2023/0463

Change of use of the existing retail shop areas into residential use and associated internal and external alterations to the buildings including removal of shop fronts and demolition of existing outbuildings to create 3no dwellings with gardens and parking area to rear in place of 2no shops and 2no dwellings

163, 165 - 167 Midland Road, Royston, Barnsley, S71 4BZ

FIRST FLOOR PLAN

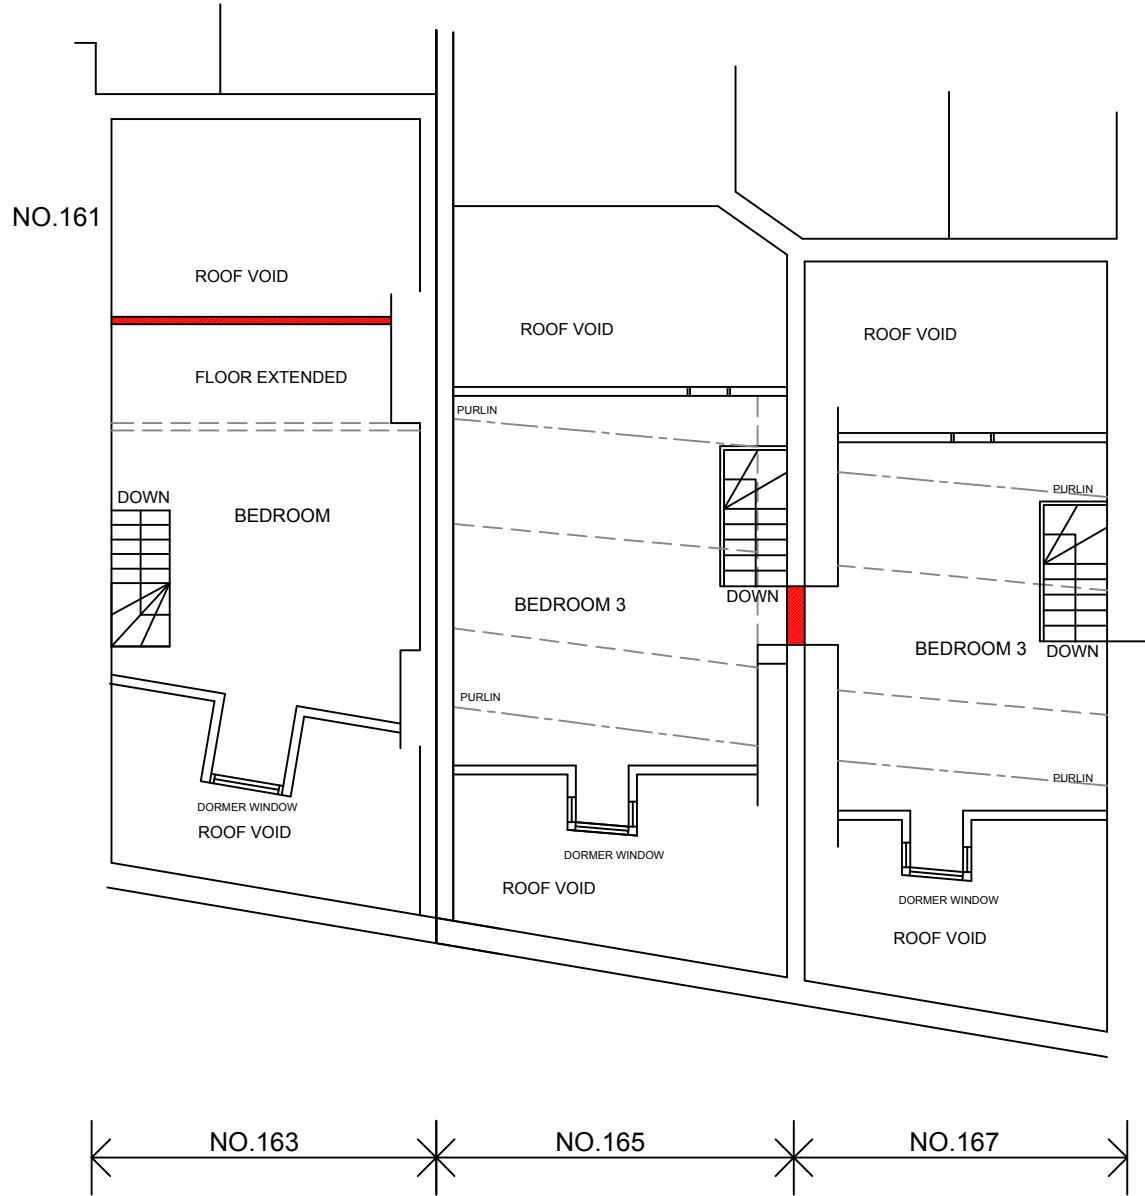
Highways DC – Initially queried various aspects of the development including details of visibility, driveway width, bin storage and turning space. Upon receipt of an amended plan indicating these details, no objection was raised to the scheme subject to a condition relating to hard surfacing of the access and driveway areas.

The proposed private external space falls short of the minimum requirements in the Council's SPD for Design of New Housing Development for three-bedroom properties with no. 163 having 34sqm, no. 165 having 36sqm and no. 167 having 39sqm – which are less than the required 60sqm in the SPD. However, there is inherent difficulty in achieving the required 60sqm given that the development is for a conversion of existing buildings and there is also the requirement to create on-site parking to the rear of the properties, which reduces the proposed external area.

There was initial concern that the proposed plots and placement of windows would result in overlooking to each other's habitable room windows and rear garden areas. To alleviate this impact, several windows will be obscure glazed such as the first-floor windows serving no. 165's study and bedroom 2. A note has been added to the plan to this effect and a planning condition will be added to any forthcoming approval notice. Other windows serving bathrooms will be obscure glazed also for general privacy purposes.

There were also slight concerns raised with the lack of suitable outlook from the proposed dwellings, which would be exacerbated by the erection of boundary fencing in the rear external areas. However, clarification has been provided by the amended plans which show that the fencing between nos. 165 and 167, immediately adjacent to the dwellings themselves will be limited to a height of 1.2m to allow for some outlook from both properties. This will mean that the properties are not entirely private but this relationship between the three properties is similar to that of other terraced housing in the Borough, and in the local area which Midland Road is characterised of.

The proposed dwelling all have one parking space to the rear of each plot site which is less than the required two parking spaces within each three-bedroom plot as required by the Council's SPD for Parking. However, Highways DC have been consulted and have allowed some flexibility given the central location of the site within the District Centre of Royston, the close proximity to local public transport links and the character of the area with the vast majority of properties on Midland Road not featuring any off-street parking. Additionally, the existing properties contain residential units in the first and second floor with two-bedrooms which do not benefit from any off-street parking, and the proposed parking arrangement is considered to be appropriate.
